# PLANNING BOARD REPORT PORTLAND, MAINE

Residential townhouse - 6 unit condominium  
133 York Street  
Level III Site Plan and Subdivision  
Project ID 2013-187  
133 York, LLC, Applicant

Submitted to: Portland Planning Board Public Hearing Date: November 12 <sup>th</sup> , 2013	Prepared by: Jean Fraser, Planner Date: November 8 <sup>th</sup> , 2013 <b>Planning Board Report # 50-13</b>
---	--

feet

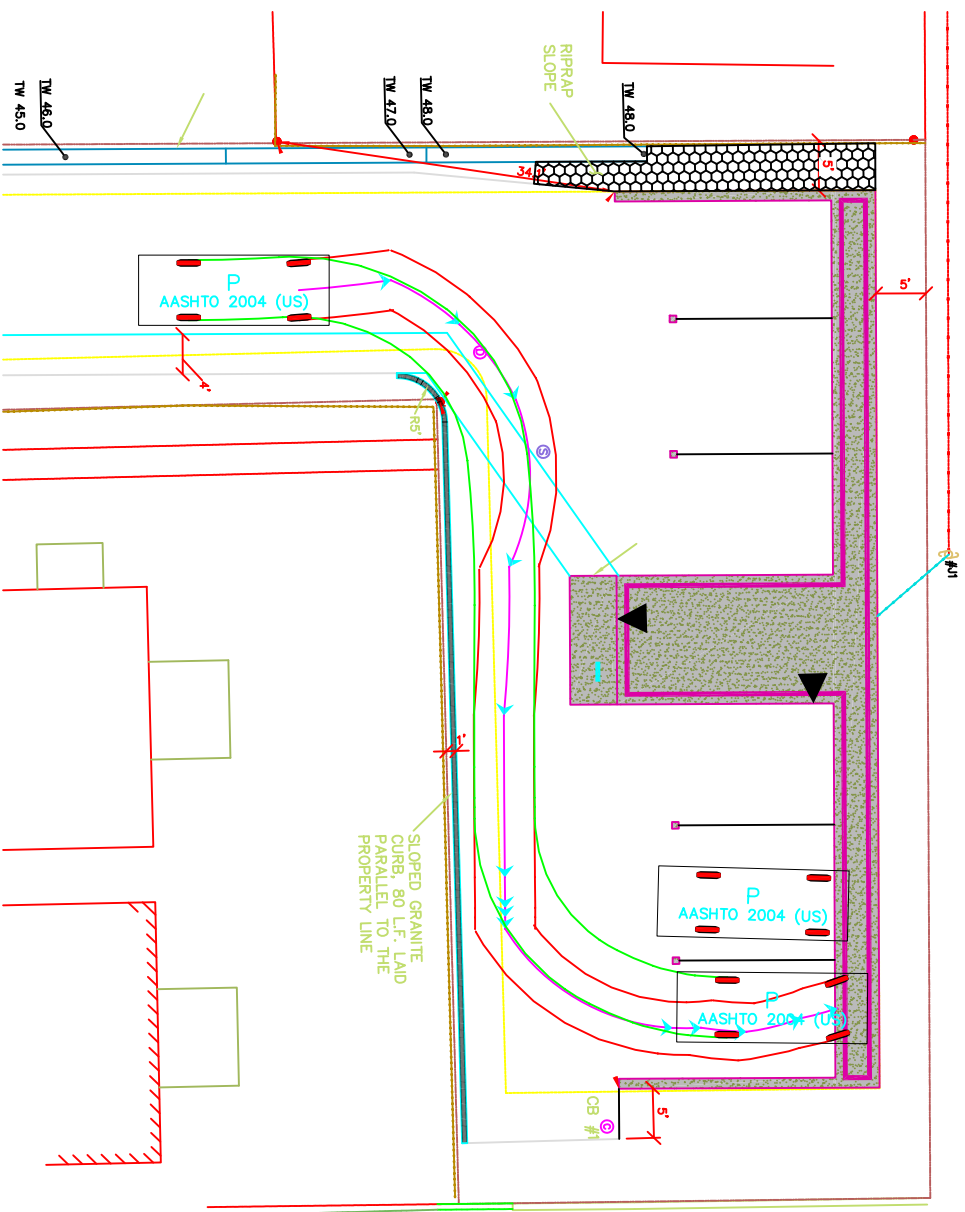
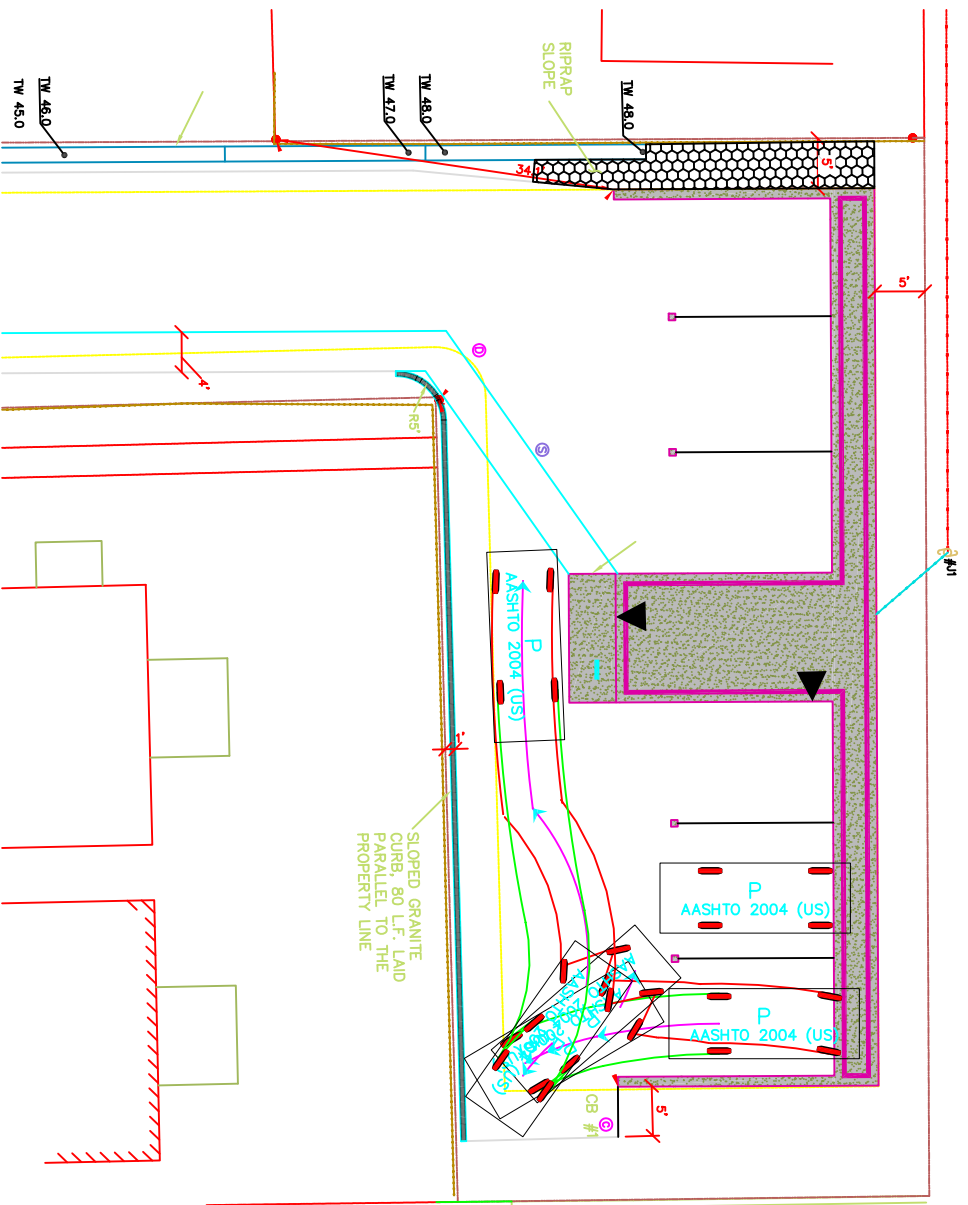
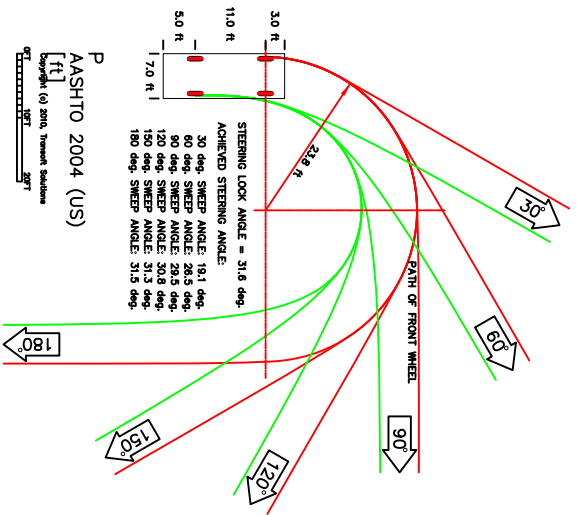
The size and placement of the building results in a narrow parking aisle leading to the 6 parking spaces located underneath the building. This potentially could cause congestion if the layout encouraged residents to back out of the drive onto York Street, which is heavily trafficked at this location near the bridge to South Portland. For this reason the Traffic Engineering Reviewer, Tom Errico, requested turning templates to illustrate the feasibility of access/maneuvering (Attachment 2). These were submitted and two of the parking spaces appeared

difficult to access (see [Attachment Y](#); an example is at right); Mr Errico wanted to confirm the adequacy of maneuvering space, as he has commented ([Attachment 14](#)):

- Access and egress movements into the garages appear difficult given the narrow pavement area. The applicant shall provide turning template graphics for a standard passenger car illustrating the ability of vehicles to adequately circulate on-site.

Status: The applicant has provided the requested turning template graphics. Given site constraints, I also requested that the applicant provide a simulated site layout in a parking area so that I could determine if vehicles could access/egress the parking garages. Based upon the field study, some garages will require multiple maneuvers (k-turns) to enter and exit the garages. The site is very constrained and the ease in which vehicles can make their intended maneuver will be a function of the design vehicle. My field simulation was based upon a Subaru station wagon and this represents a mid-size vehicle. Large Single-Unit Vehicles (SUV) will have greater difficulty.

With all that said, I do support a waiver from our technical standards for parking lot aisle width dimensions. The waiver is suggested given the unlikelihood that vehicles will back down the driveway into York Street. There is a significant distance between the garages and York Street, and thus feel that all maneuvers will occur on-site. I would note that the bicycle rack should be relocated so that it does not impede circulation. Additionally, it will be very important that snow removal/maintenance is effective so that snow does not further constrain the site.

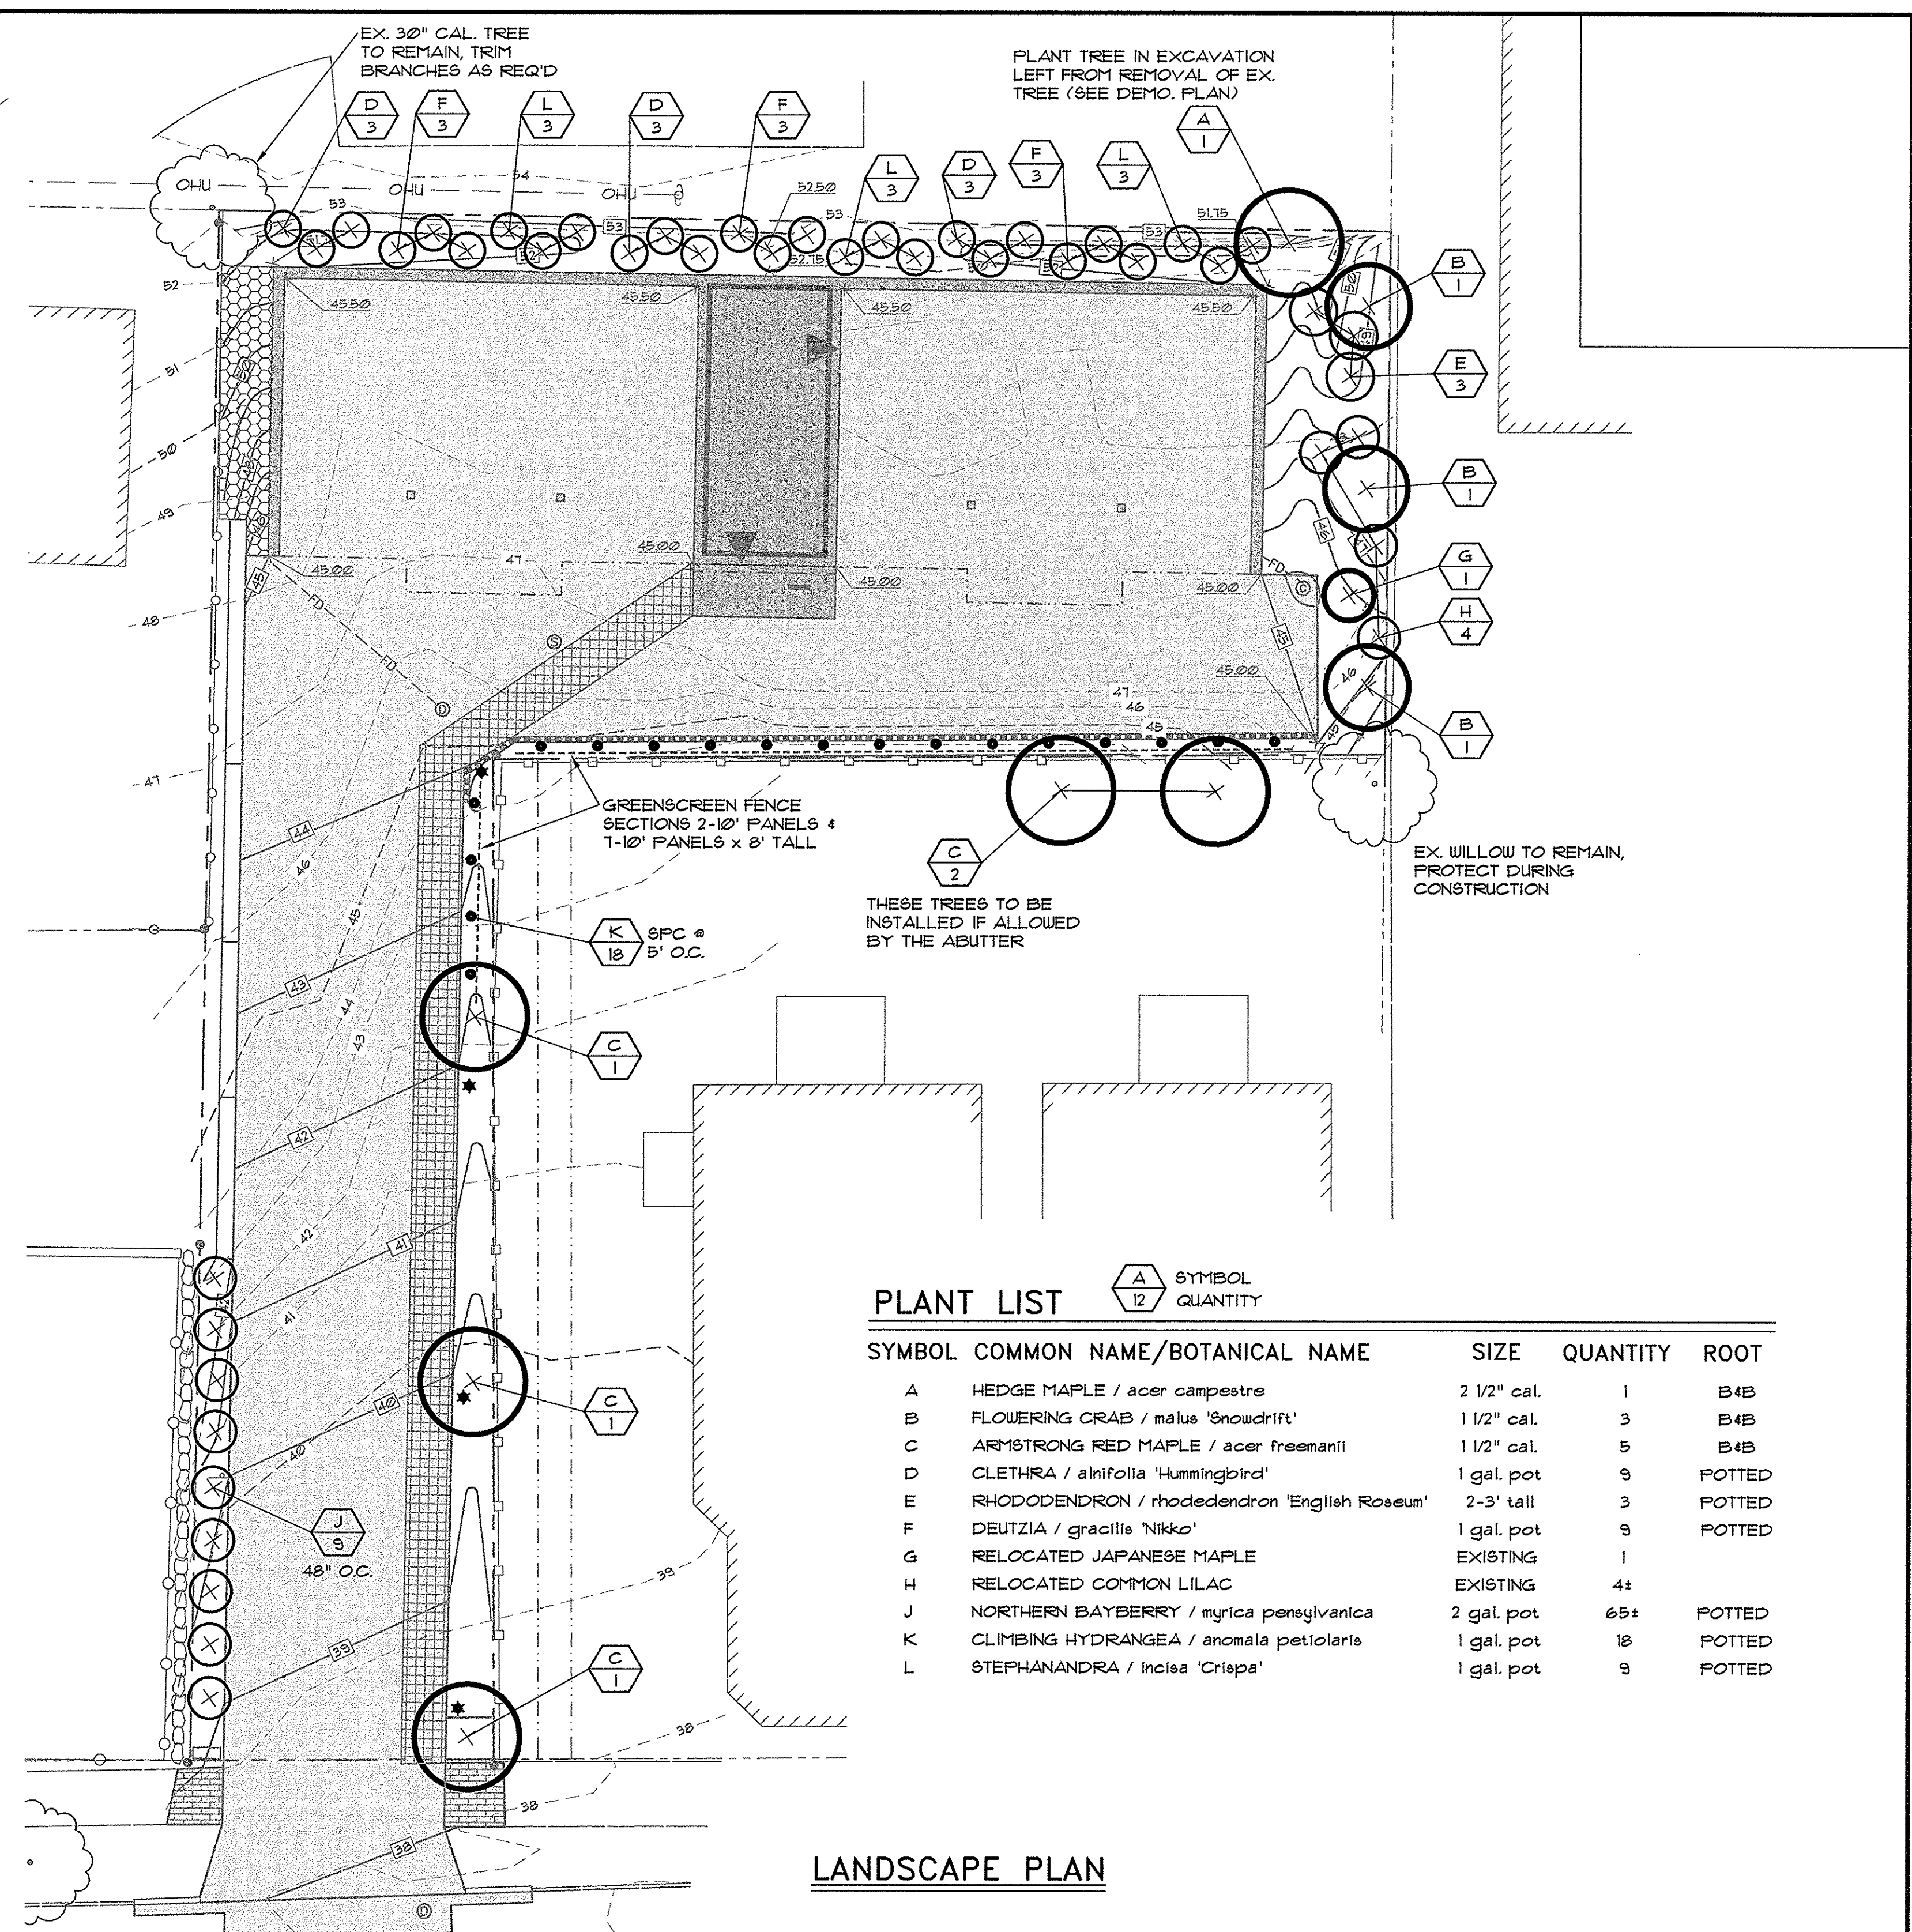
The Landscaping Plan (Plan 6) proposes the planting of 7 trees: 4 at the eastern side of the building and 3 along the access drive. Bayberry planting is proposed near York Street and shrub planting is proposed along the rear boundary where the final levels will be raised.

*a) **Landscape review** - The proposed development at 133 York Street presents challenges to meet standard landscape treatment due to the shape and constraints of the project site. The project does offer landscape amenities such as a green wall to provide screening along with two off-site tree planting locations if agreeable. The building footprint close to existing building site poses challenges to screen but improves on the long existing conditions. Two mature trees are close and will likely have impact during the construction process. Best practices in regards to tree protection are needed to prevent / reduce root zone damage.*

*b) **Landscape plant material: plant sizes - Condition**) shrub stock noted as "D" Clethra, "F" Deutzia, "J" Northern Bayberry, "K" Climbing Hydrangea, "L" Stephanandra shall all be #3 pot size minimum and tree sizes should be the following: "B" Flowering Crabapple 1.75-2" caliper, "C" Armstrong Red Maple 2" caliper. Items mentioned as "Existing", "G" Relocated Japanese Maple (#5 pot size), "H" Relocated Lilac (3-4'H) should also have these sizes as replacements if the relocation is not successful. (Too often good intent to save plants through construction are less than successful).*

*c) **Green wall** - the proposed project use of a green wall will help screen / buffer the adjacent building. The green wall plant type: Climbing Hydrangea is slow growing, and thus the proposed 1 gallon pot size much to small to be effective for many years... recommendations & condition the green wall plant sizes must be #3 pot & #5 pot sizes alternating minimum to provide a good start for the green wall. (from 11.4.2013 comments): A solid screen such as a fence, would not, in my view, improve the proposed.*

A potential condition of approval requires the revision to the Landscape Plan to incorporate these recommendations.
